CITY OF ALBUQUERQUE

**RE: Taco Bell – Snow Vista Blvd
Grading & Drainage Plan
Engineer’s Stamp Date: 8/8/2025
Hydrology File: M09D012D**

Based upon the information provided in your submittal received 11/24/2025, the Grading & Drainage Plan is not approved for Building Permit. The following comments need to be addressed for approval of the above referenced project:

C501

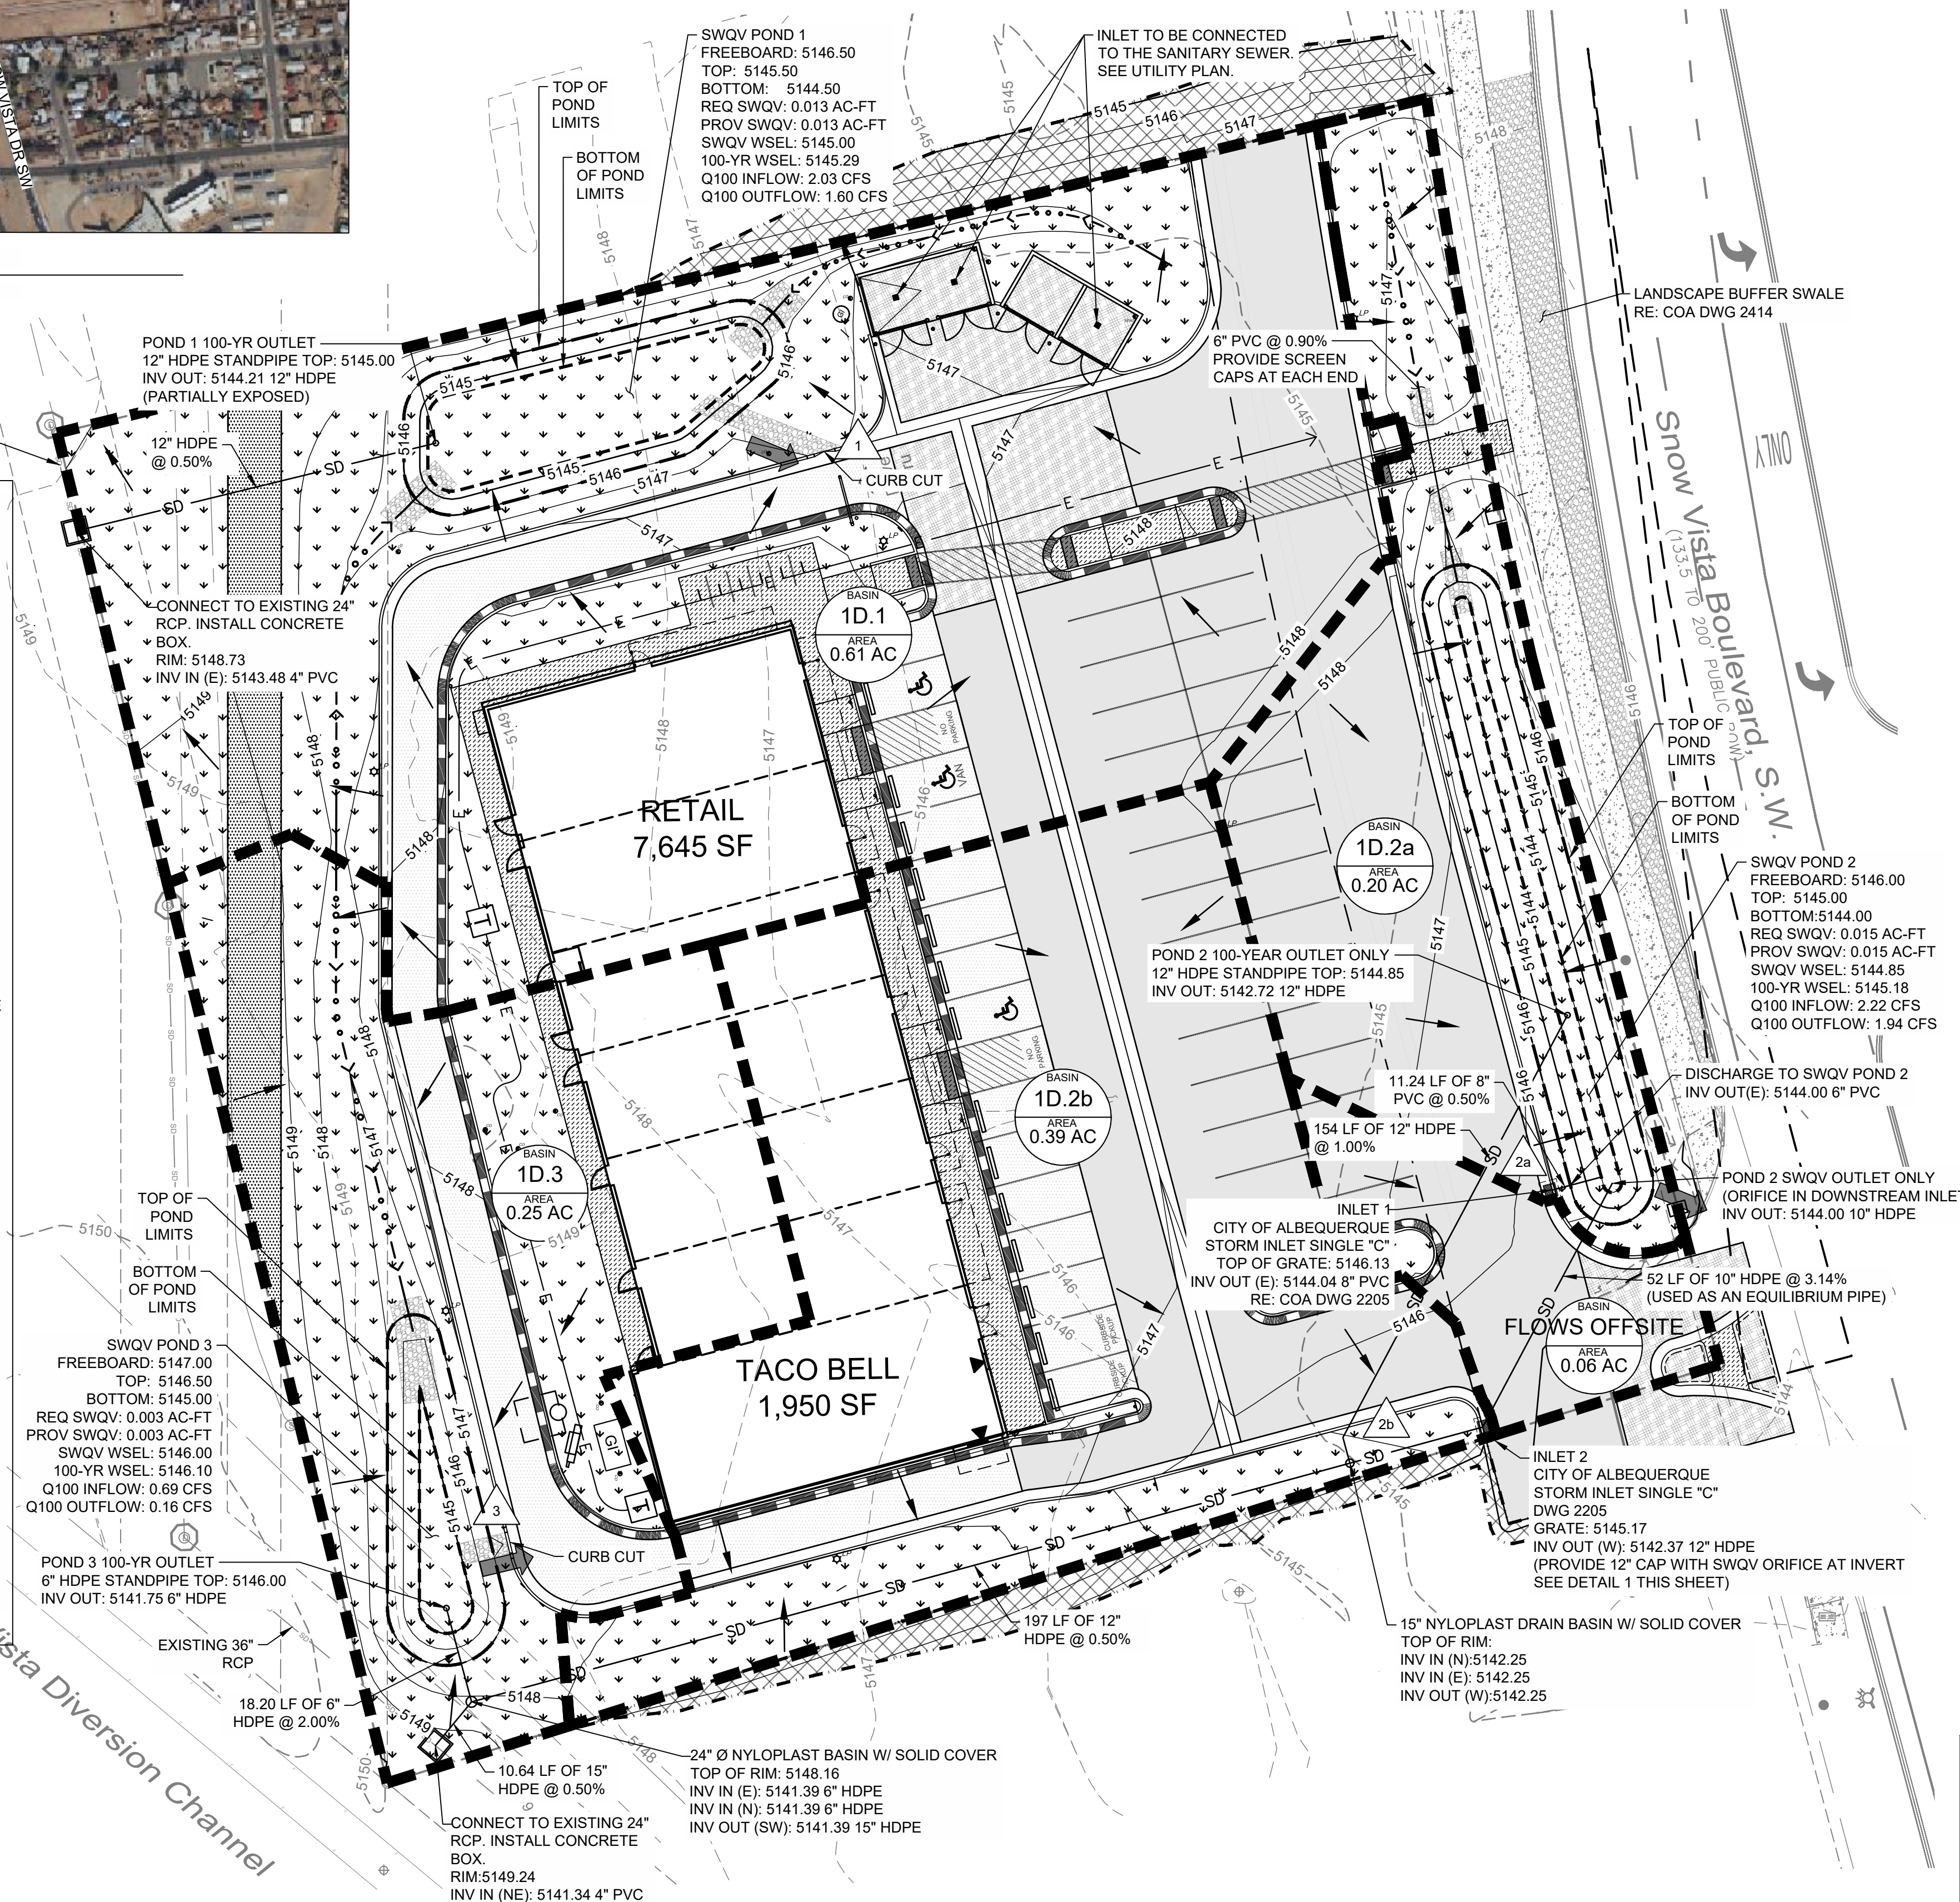
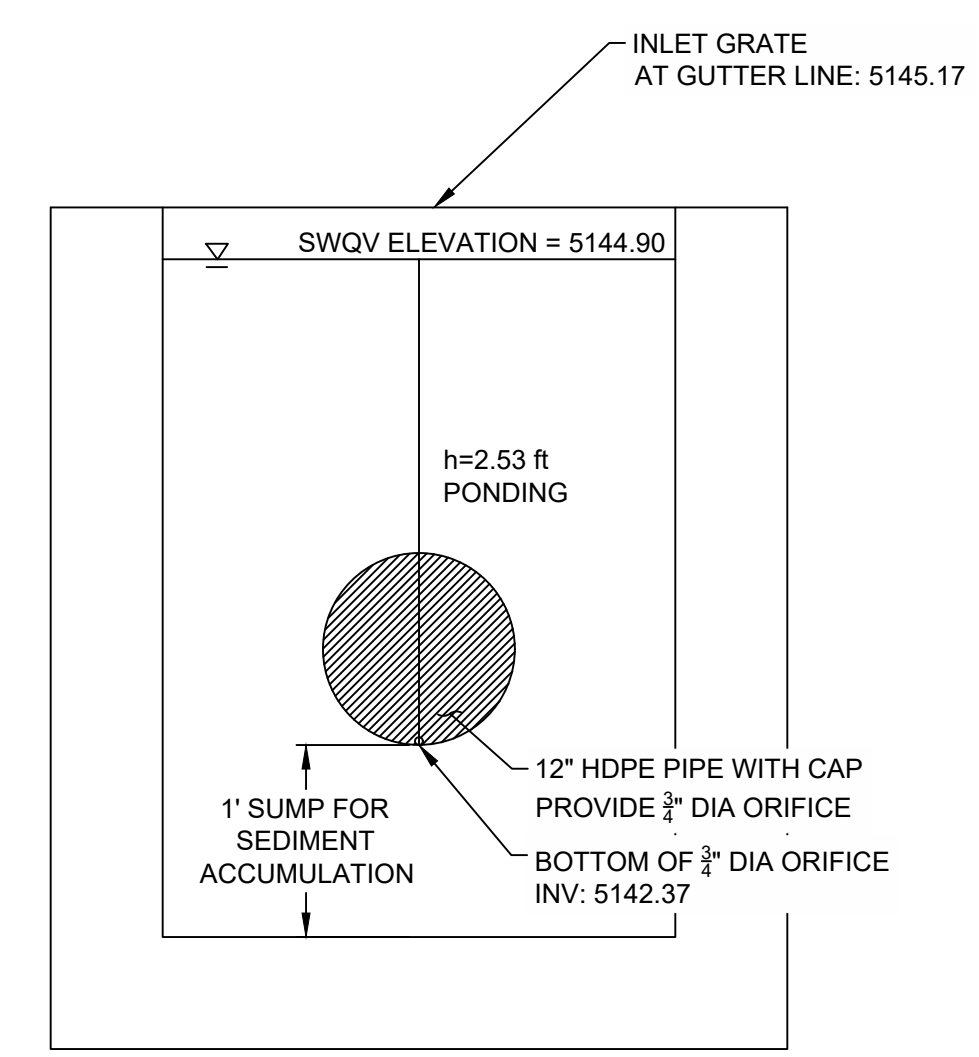
SHEET C501 (Should be C502 since this is the second C501)

Please verify the weighted E and volume numbers. I couldn’t get the same results. Also, the weighted E dimension should be “ft” instead of “ac-ft”.

ACKNOWLEDGED. SHEET NAMING AND NUMBERING HAS BEEN UPDATED.

THIS TABLE HAS BEEN UPDATED. THE WEIGHTED E DIMENSION NOW HAS THE UNITS OF INCHES RATHER THAN FEET OR AC-FT. THIS CLOSELY MATCHES EQUATION 6.1 IN THE DPM.
